2 November 2022

Planning application FP/22/2447

Referring to the above application, I have the following concerns and objections. It is proposed to build a 2 storey 4 bedroomed 4 bathroom house on the land edged green and hatched black on the attached plan.

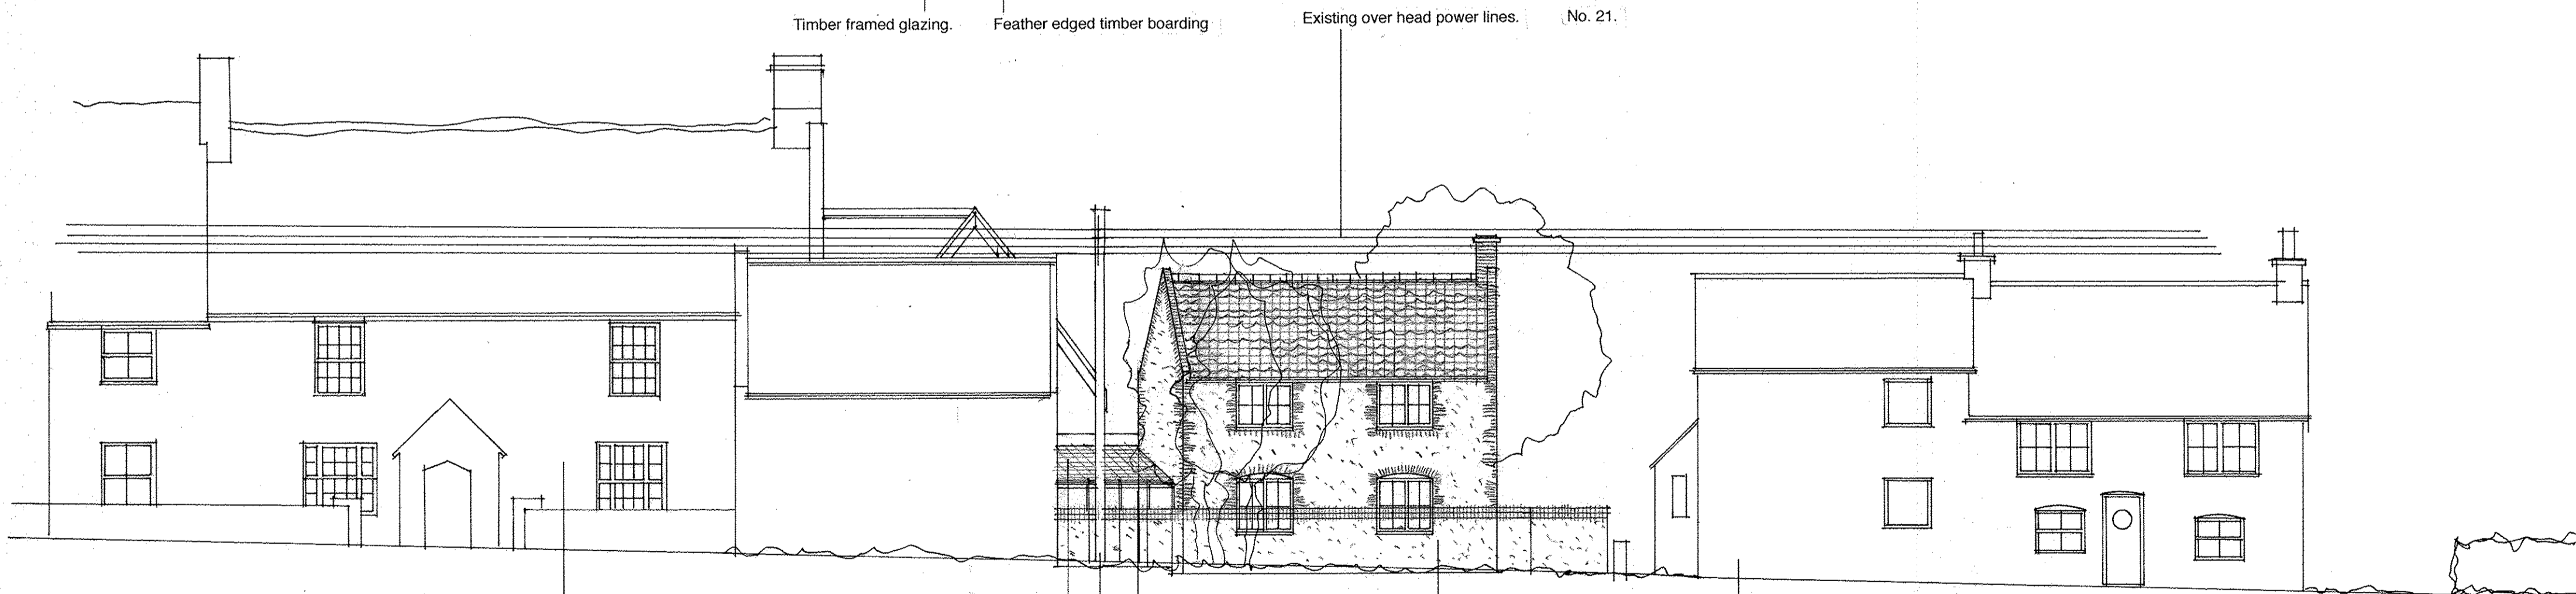
5. Windows on the east elevation look directly into my garden thus causing a privacy issue for me.

6 What is happening to the enormous, I think Sycamore tree on the east elevation of the proposed development? .
